Re: Construction at 8801 Glendale Ave NE not in Compliance

Hydrology recently visited the home under construction at 8801 Glendale Ave NE for Floodplain Development Permit compliance. Per FEMA regulations, a Floodplain Development Permit was approved for construction of a home per the approved grading and drainage plan (B20/D021).

GARY PADILLA RESIDENCE 8801 GLENDALE AVE. NE ALBUQUERQUE, NEW MEXICO 87122	LOT 22 BLOCK 16 TRACT 1, UNIT 3 N. ABQ. ACRES
	GRADING & DRAINAGE
DATE: JULY, 2011	
SCALE: 1" = 20'-0"	
FILE: 8801 - DRN

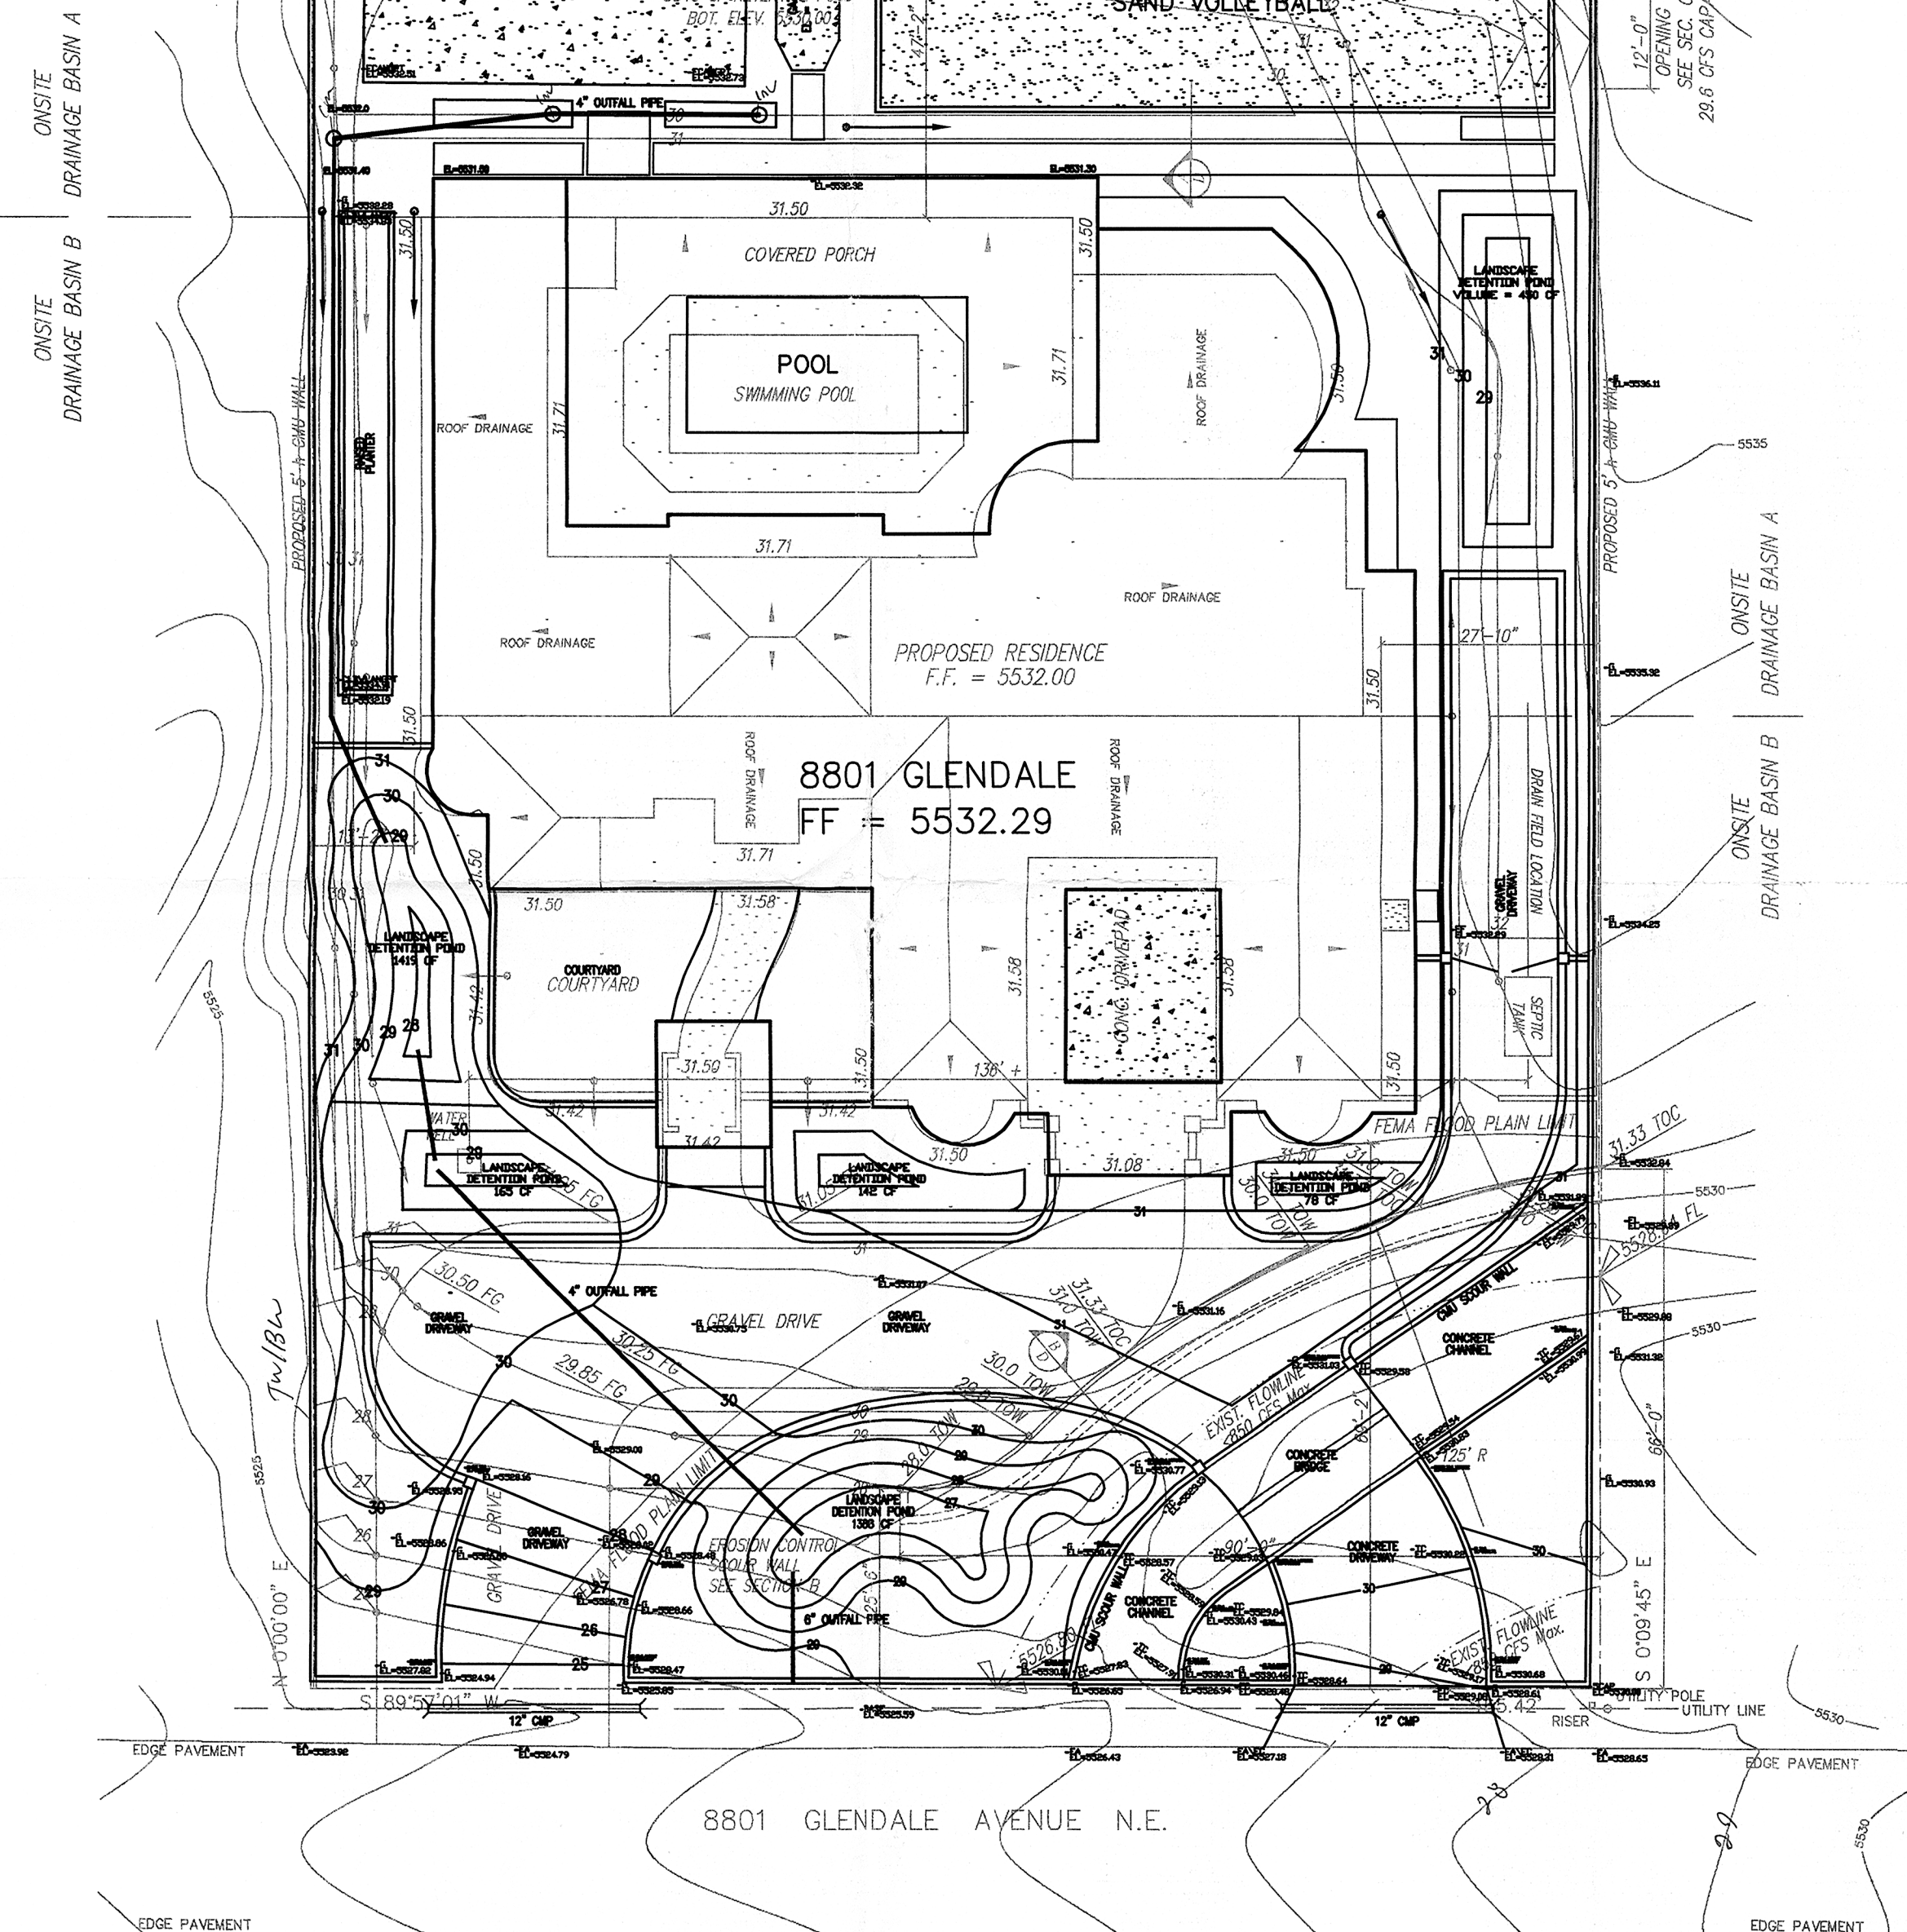
It appears all of the above referenced objectives have been ignored. Constructing the wall in the arroyo will raise the water surface elevation on adjoining lots and possibly cause damage property. Exceeding the amount of impervious area will produce additional runoff and possibly cause property damage. Not accepting offsite flows through the wall may cause property damage. These are violations of the drainage ordinance. See section §14-5-2-12.

Hydrology is requiring the wall and driveway that were built in the floodplain be removed and for the site to meet the requirements of the grading and drainage plan.
